**Proposed Wollar-Wellington 330kV Transmission Line – Letter from Mr Needham
20/12/04**

Wollar-Wellington 330kV Line and Concerns of Mr Needham, March 2005

**Diagram 3.1 –Transmission Network in the Western Area of NSW**

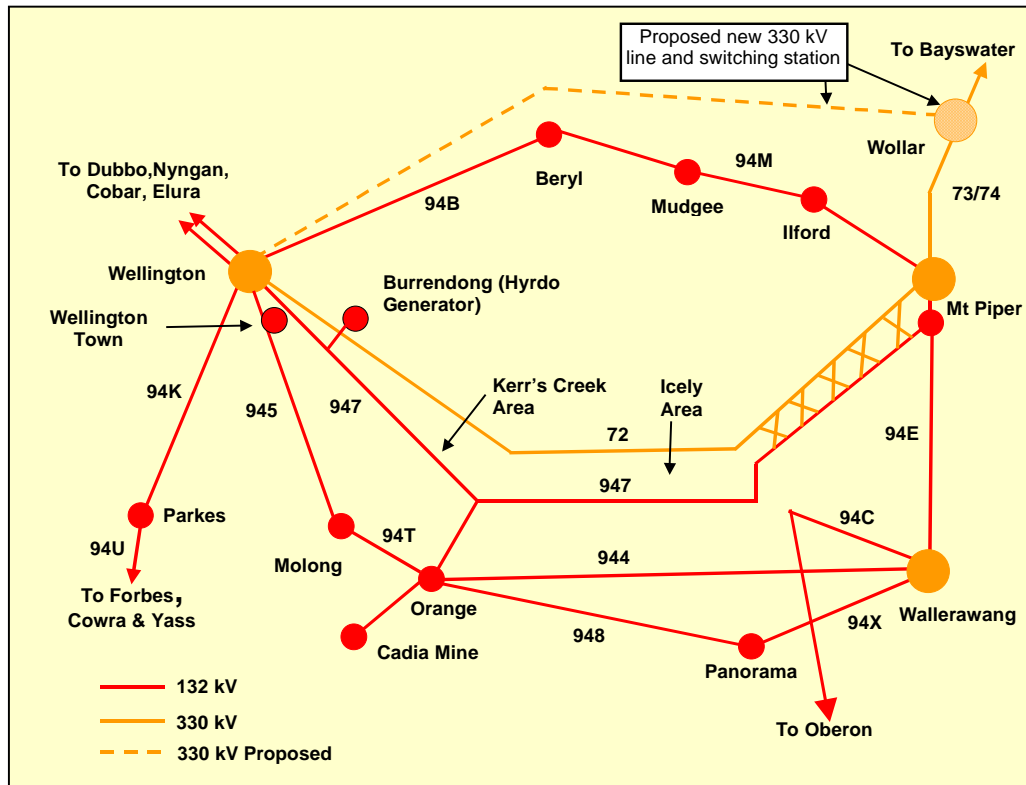
Diagram 1 & 2 Transmission Network in the Western Area show two 132 KV power lines providing power to Dubbo, Nyngan, Cobar, Bourke etc.

Question 16 Do both of the two 132 KV lines from Wellington to Dubbo continue to Nyngan, Cobar, Bourke etc? if not, where does the supply reduce to one 132 KV line and or 66 KV line?

Question 17 What was the maximum demand during summer and winter for these 132KV & 66 KV lines for years 2002,2003 & 2004?

Question 18 What was the maximum demand in winter and summer for line 94K and what is the capacity in KWH for this line?

The 132 kV network supplying Dubbo and areas to the north and west is owned by Country Energy. It consists of two 132 kV lines between Wellington and Dubbo, two between Dubbo and Nyngan and one between Nyngan and the Cobar area. It supplies 132/66 kV, 132/22 kV or 132/11 kV substations at Dubbo, Narromine, Nyngan and in the Cobar area.

TransGrid meters supply to Country Energy's network supplying Dubbo and areas to the north and west at Wellington. The actual maximum demands over recent summers and winters is shown in the table below.

Season	Maximum Demand (MW)
Summer 2001/02	139
Winter 2002	148
Summer 2002/03	142
Winter 2003	138
Summer 2003/04	147
Winter 2004	144

The power flows on the 94K Wellington – Parkes 132 kV line are generally from Wellington to Parkes. The magnitude of the flow depends on a number of factors, including:

- generation patterns;
- the magnitude of the loads at Cowra, Forbes and Parkes;
- line outages within the network supplying Cowra, Forbes and Parkes; and
- outages within the network between Wallerawang/Mount Piper and Wellington.

As the line does not directly supply Country Energy loads (they are supplied at 66 kV and 132 kV from Parkes and at 132 kV from Wellington), TransGrid has no revenue metering of flows on this line.

Provided that the voltage at the 132 kV busbar of Wellington 330/132 kV substation is in the normal range, the line has the capability to carry the load that is likely to flow on it.
